Scandia Hus Limited
Scandia Hus Business Park
1 Felcourt Road
Felcourt
East Grinstead

Your Ref :
Our Ref : A/61/13/NMA

Section 96A of the Town & Country Planning Act 1990 (as amended)
Town and Country Planning (Development Management Procedure) (England) Order 2010 (as amended) - Article 9

Application for a non-material amendment following a grant of planning permission A/53/12 -
Removal of unprotected Maple tree. Replanting of a new sappling once building is complete
Land south of Mill Cottage, Old Mill Lane, Angmering,

C/No. 134485	O/No.	SCALE 1:100/1:500
DATE 4/12	DRAWN SW	DRAWING NUMBER 01L
		REV C

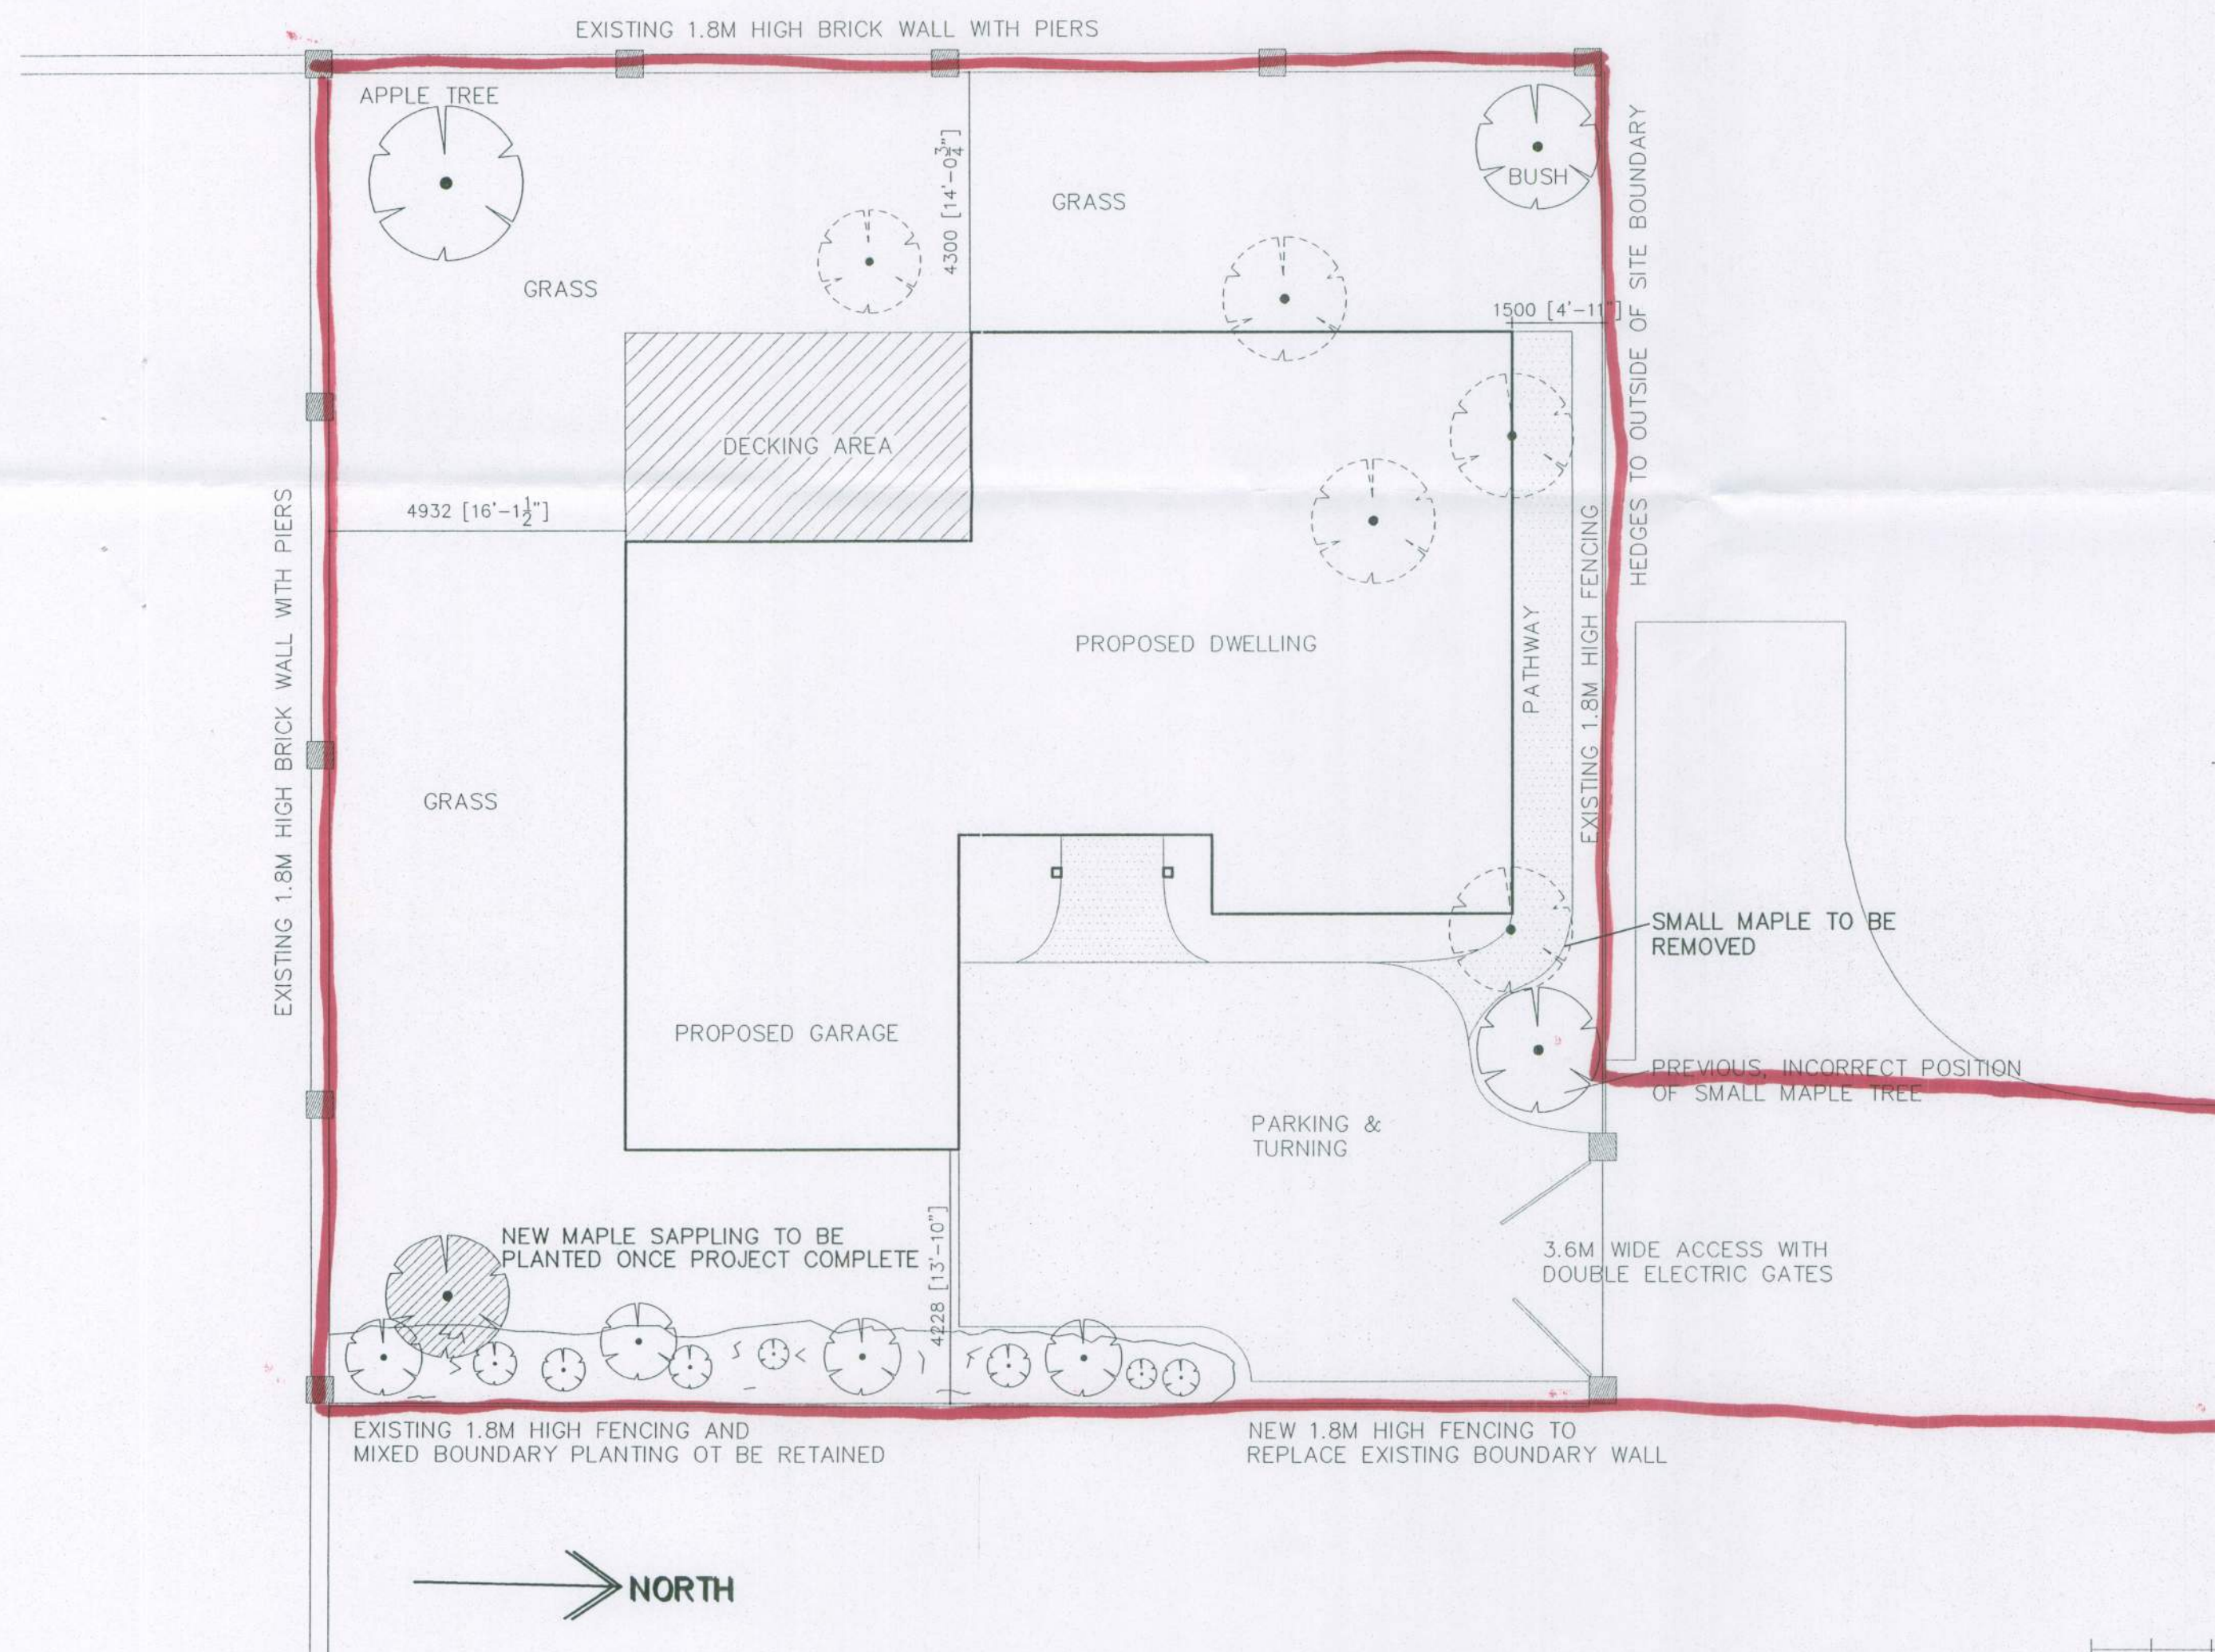
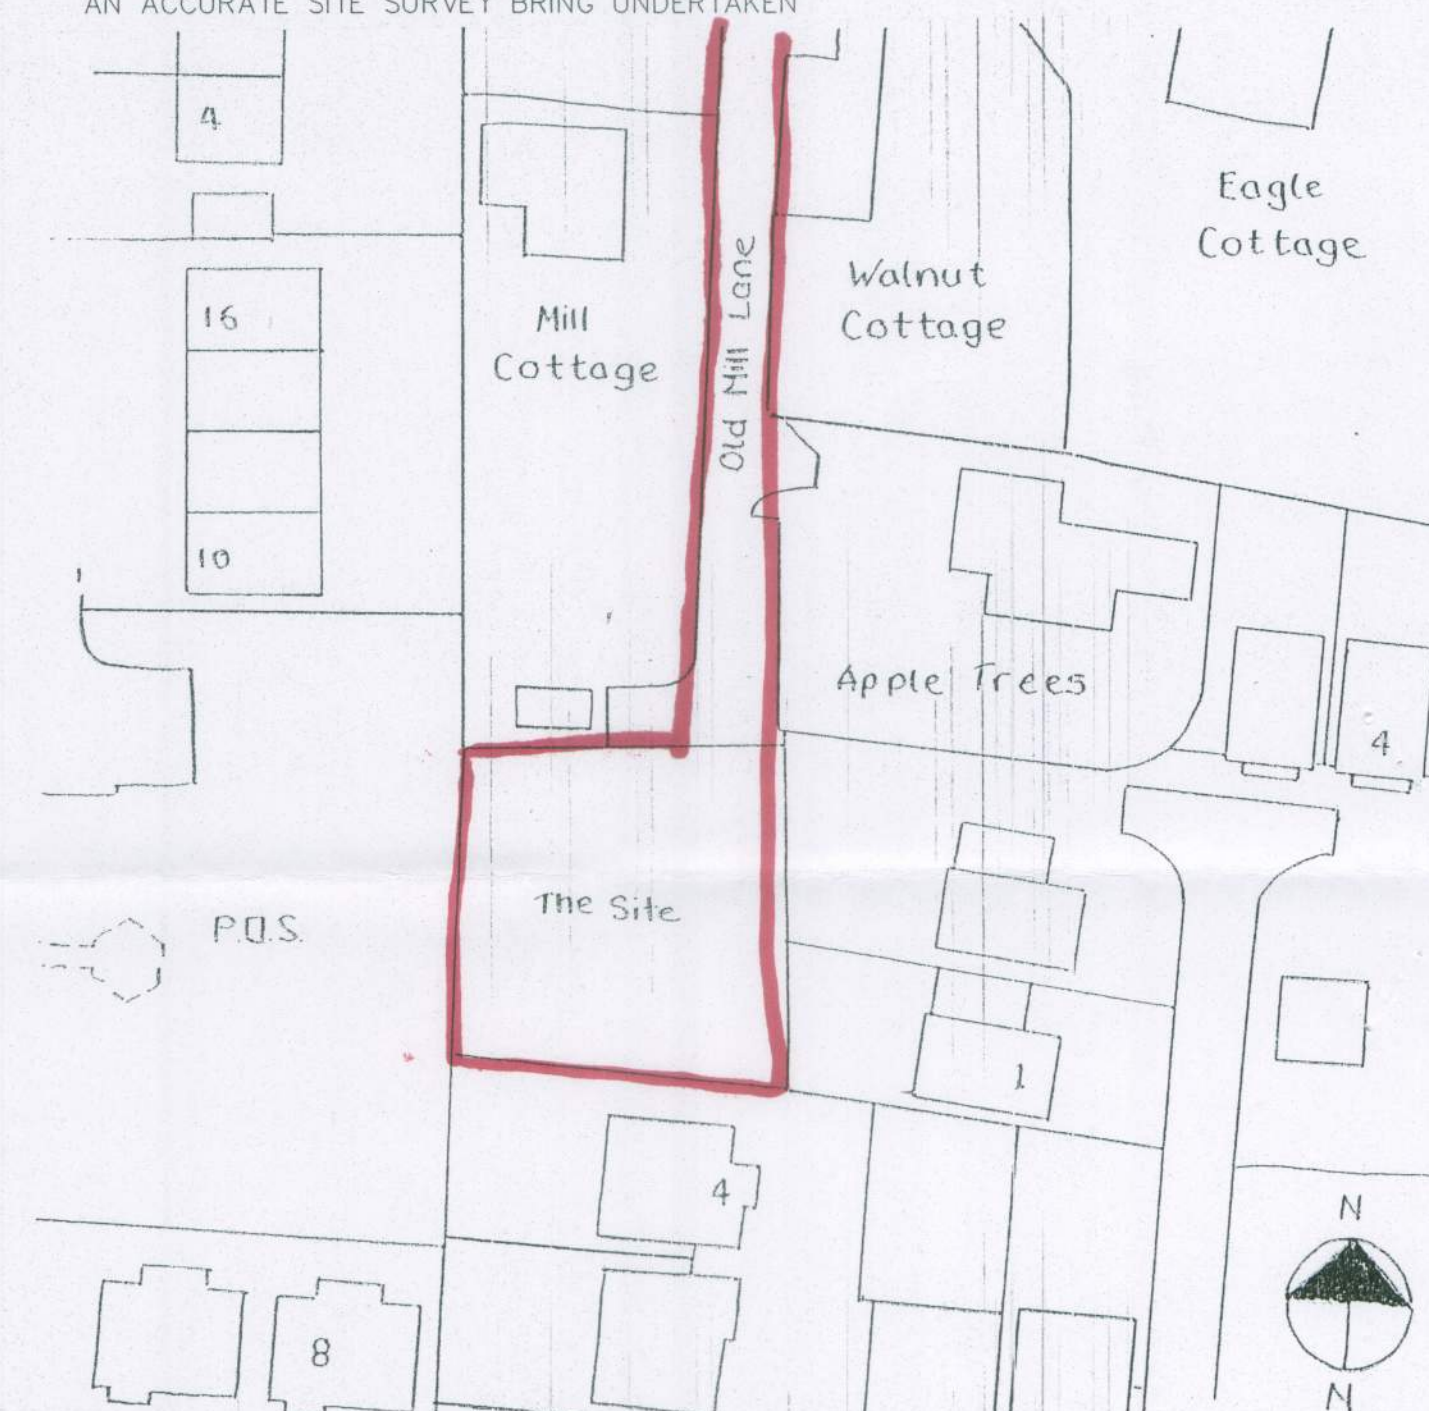
The changes proposed include the removal and replacement of a Maple tree within the site and therefore an amendment to the approved site plan listed in Condition 2 of the approval. Condition 2 is duly amended to refer to the revised plan as set out below.

This condition together with removal and replacement of the Maple tree will be accepted as a Non Material Amendment to the previous planning approval.
